About the application

Application number: 2026/91063	
What is the application for?:	Re-instatement and repair of existing building including alterations to roof and
Address of the site or building:	382, Huddersfield Road, Mirfield, WF14 9DL
Postcode:

User comments

Proposed East South East Elevation (Right)
1 : 50

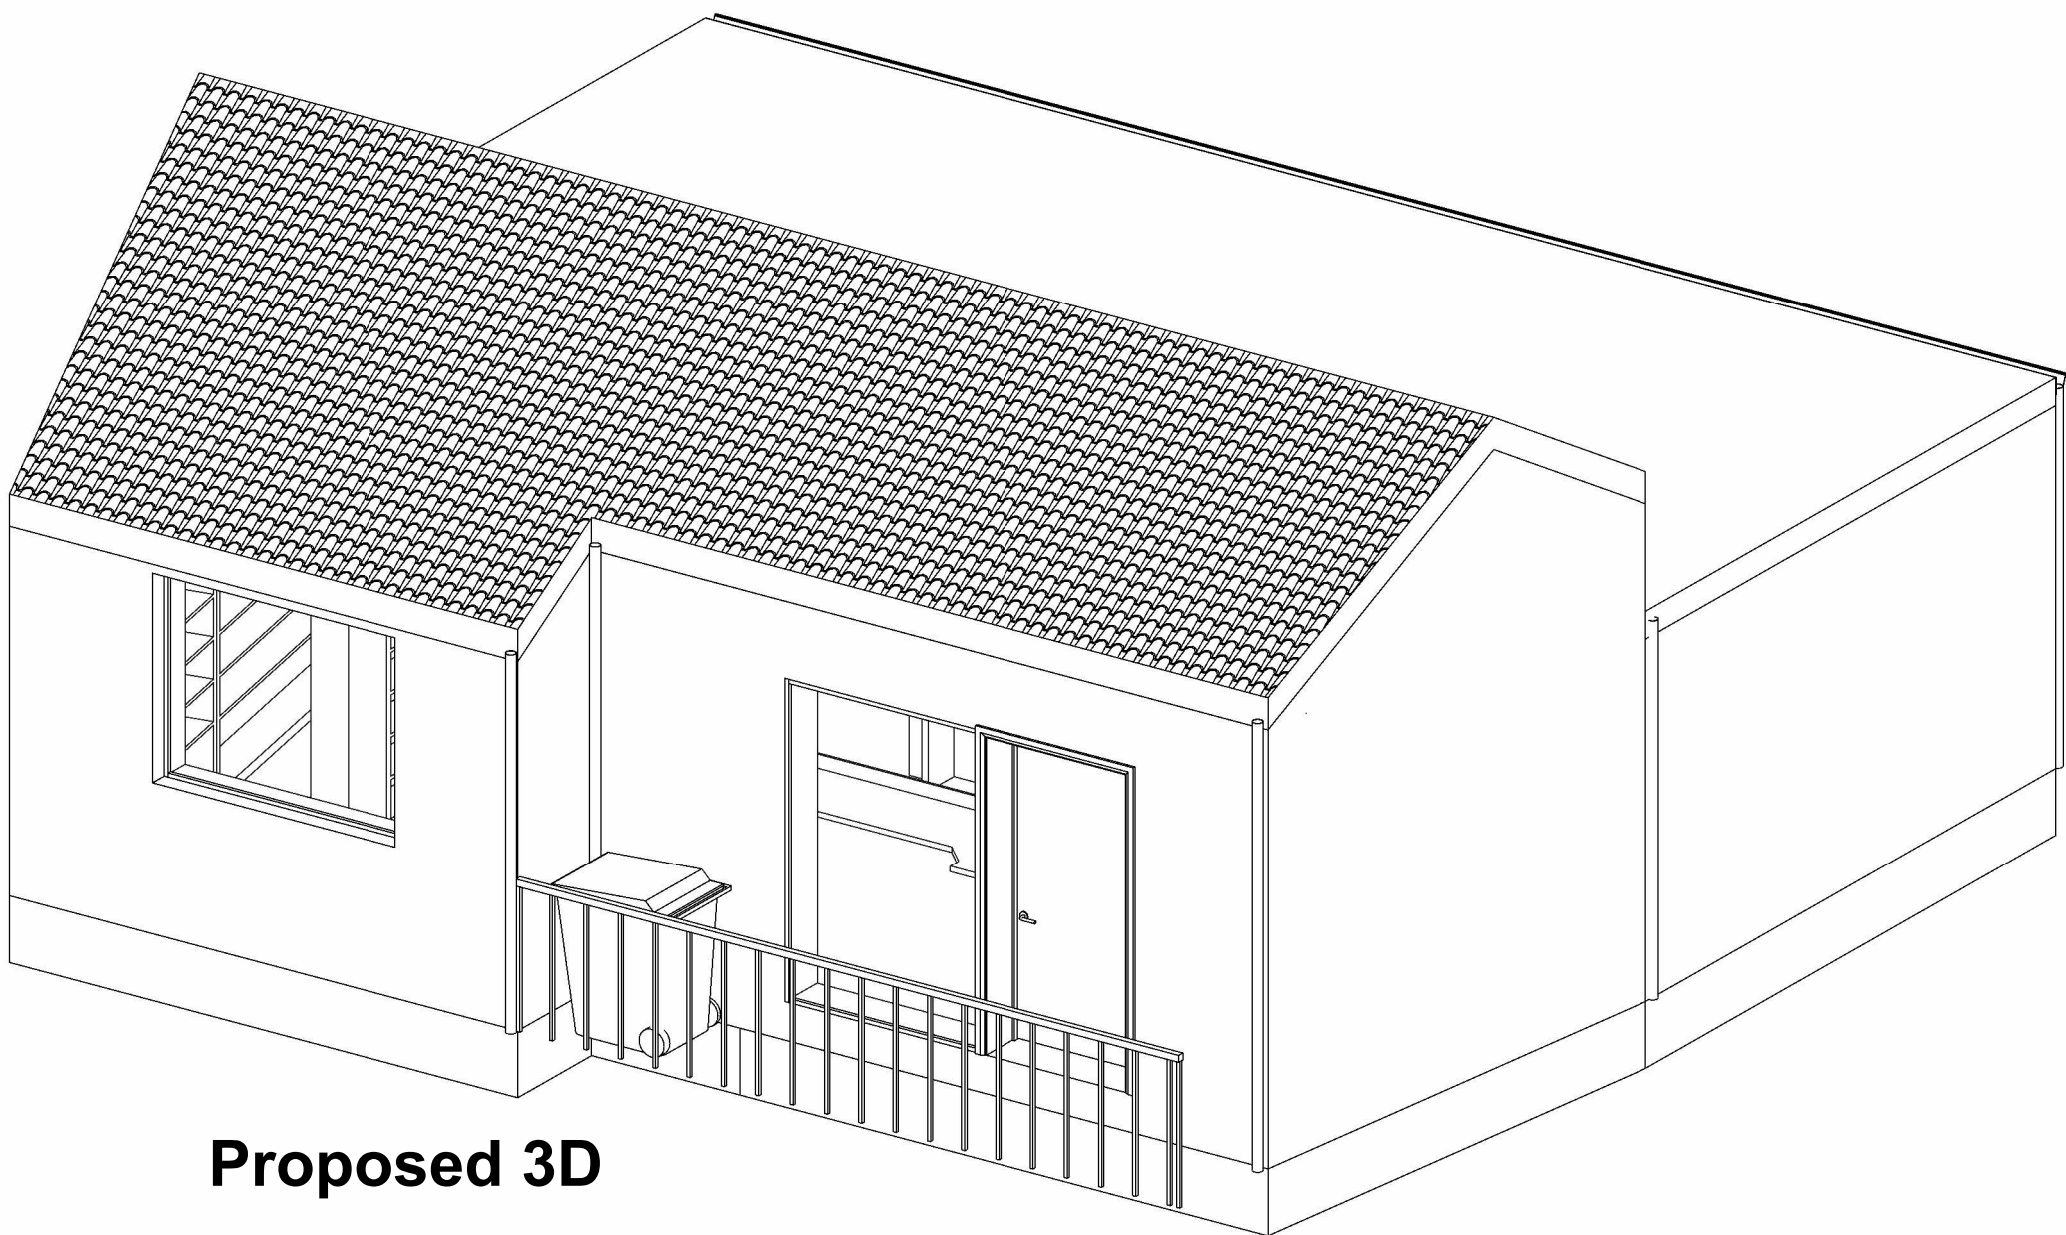
Drawing id 1135704 show the height as 4681mm

Proposed height is 4681mm

There is a public right way steps upwards next to this building ,this not shown on any drawings.

The measurements shown do not include this public right of way or the height of the steps.

There is no datum line from which the measurements are taken.

The 1 to 50 scale used only works on a specific size of drawing being A1 .Further dimensions need to be added to the plans.

This wording is a licence to build whatever size building you so wish.

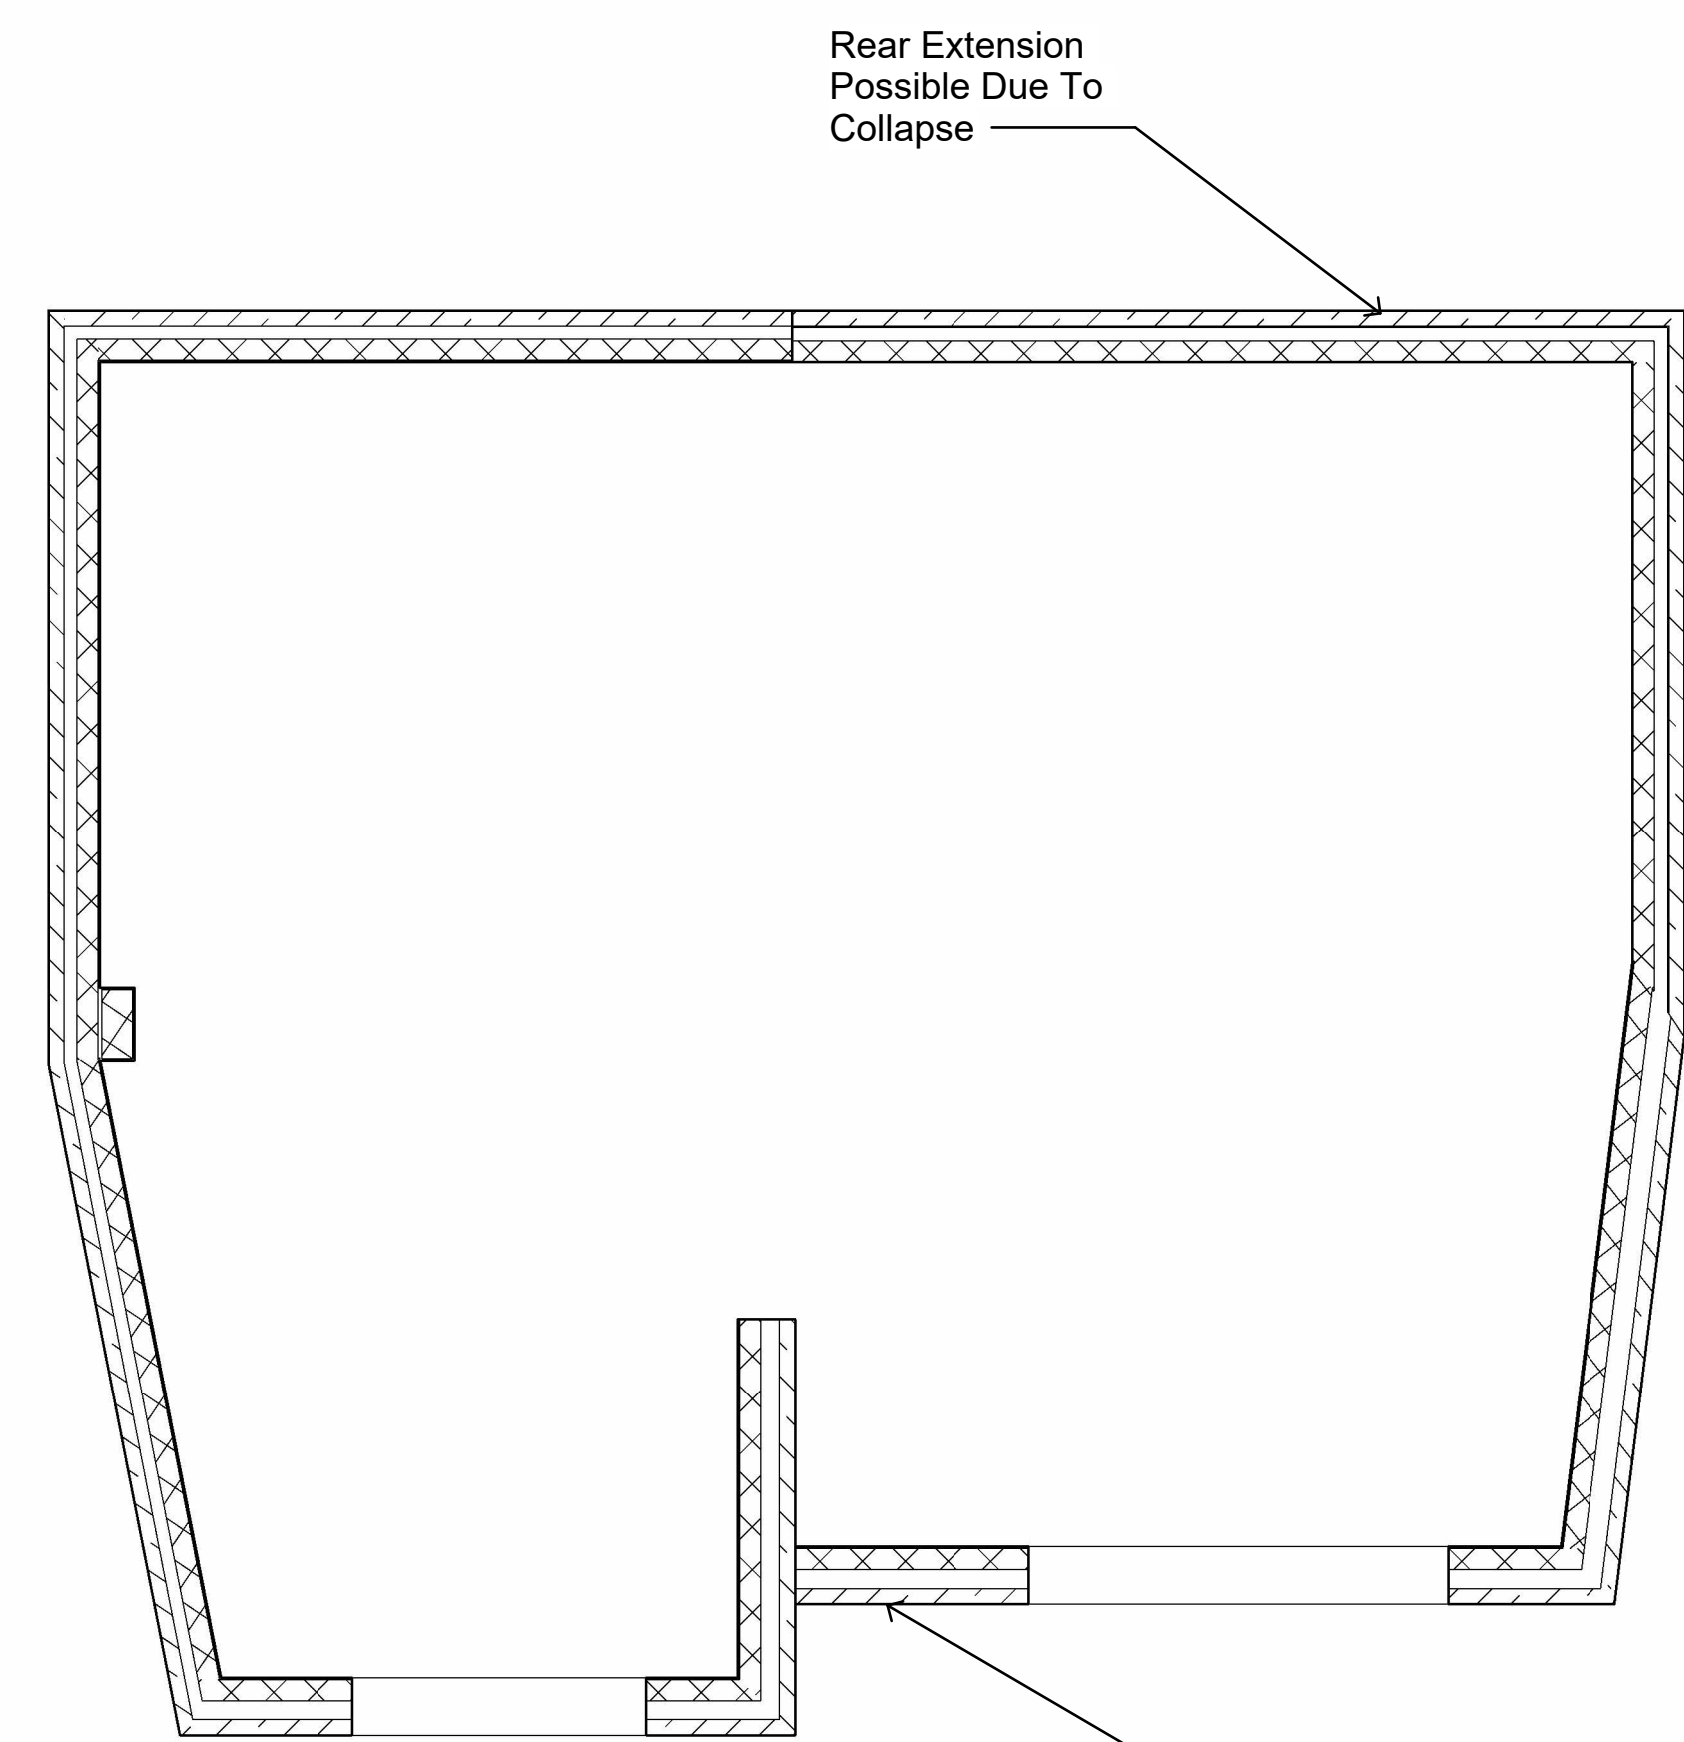
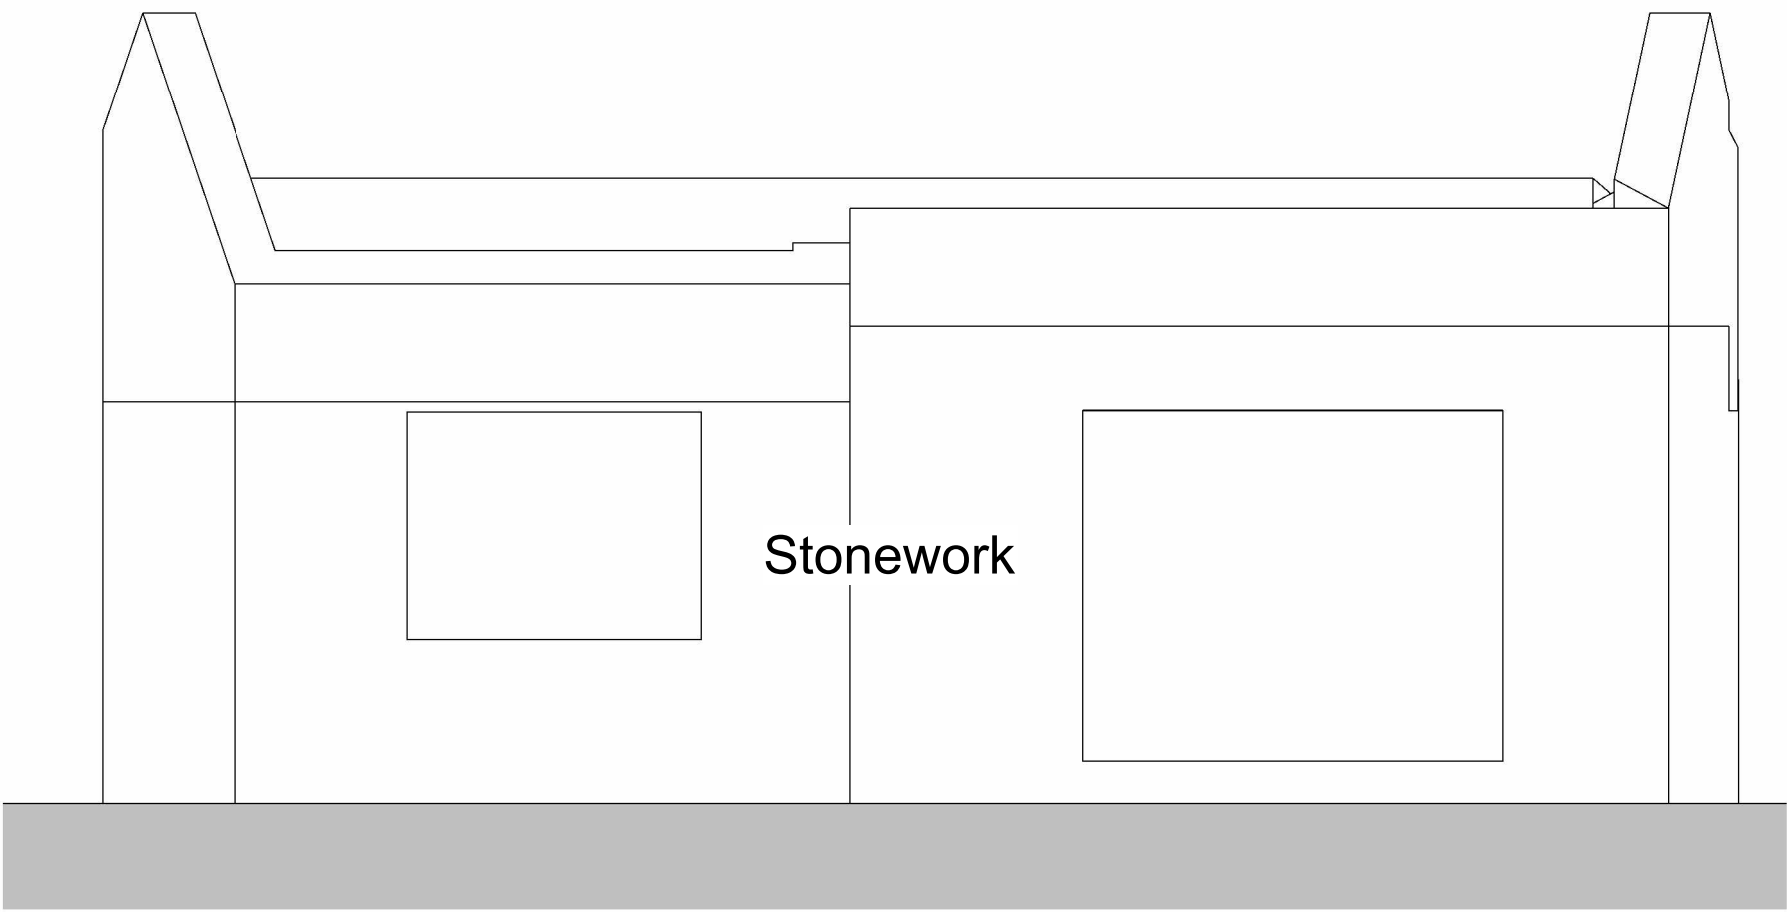
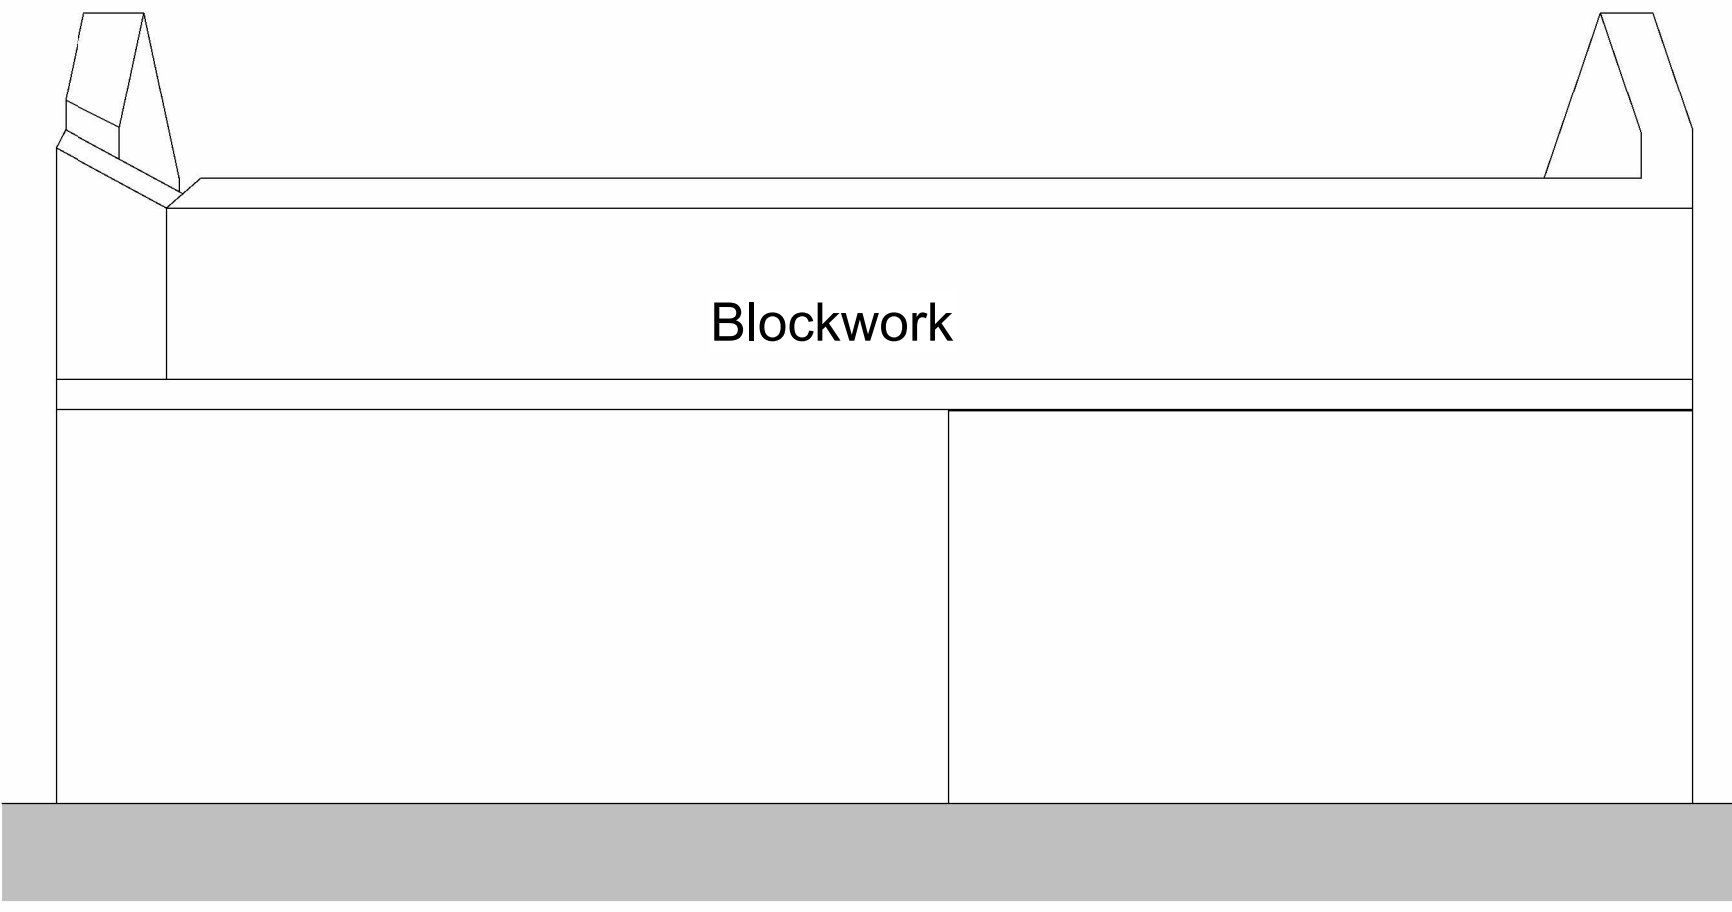
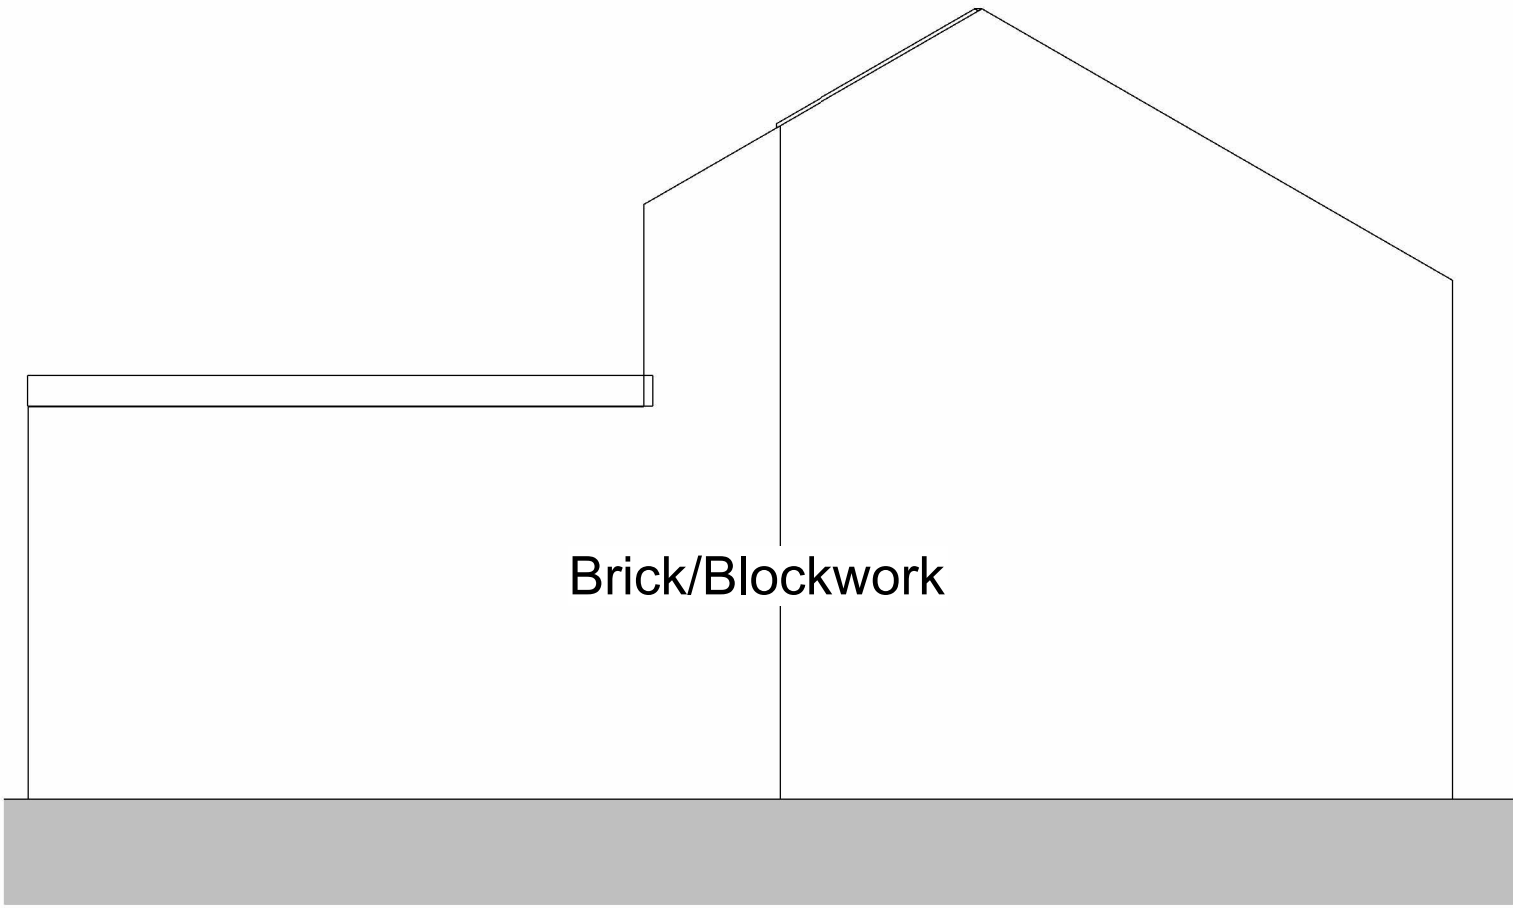
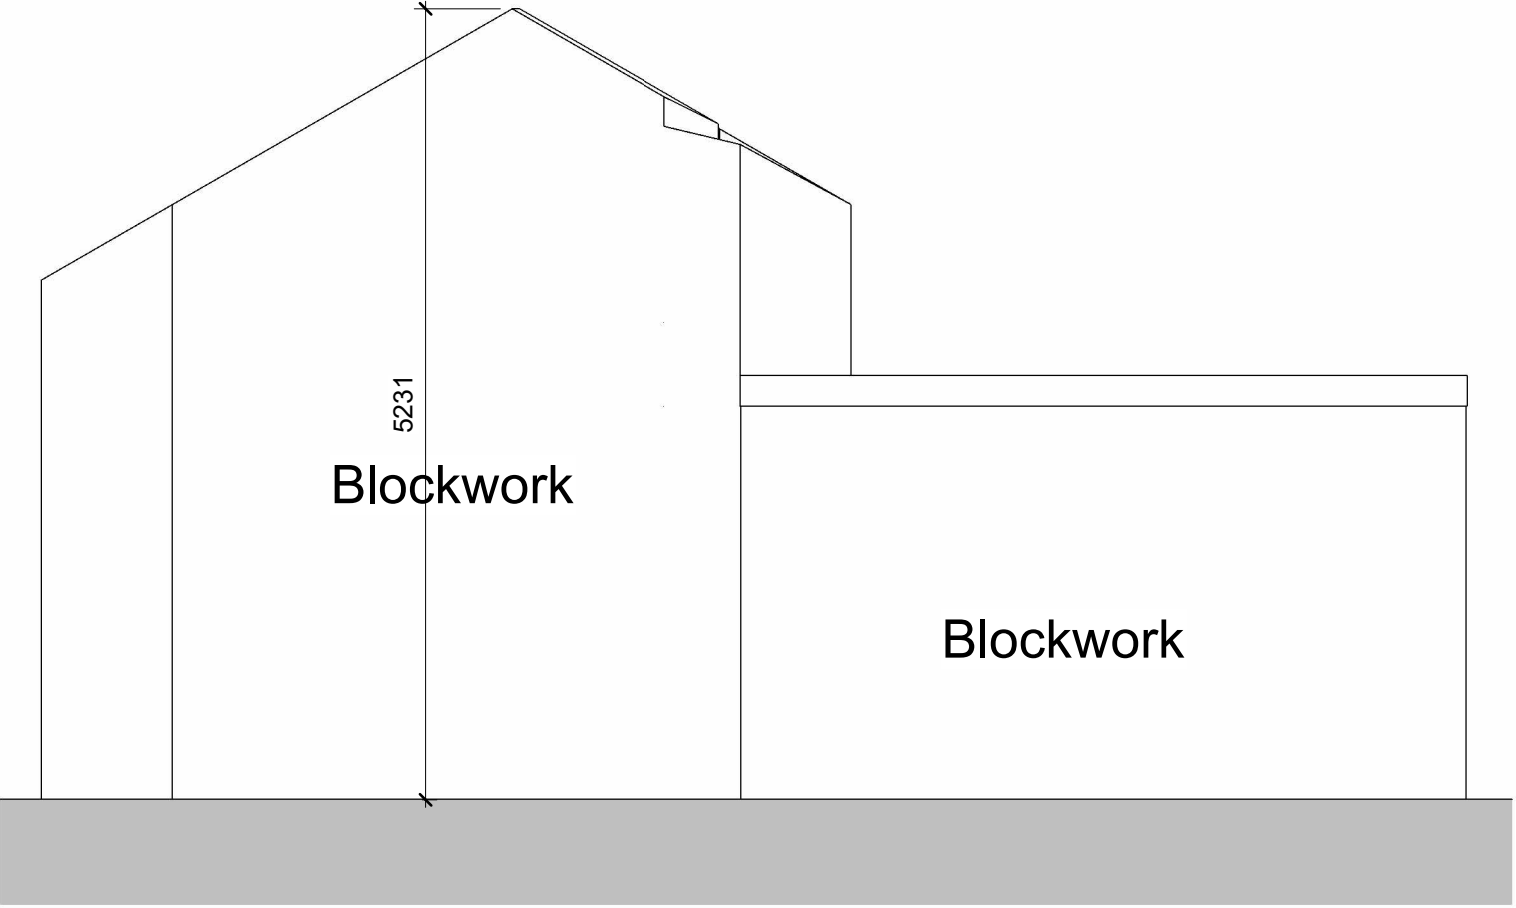
The existing that has been built without planning permission .

The as built now without planning permission is 5231mm
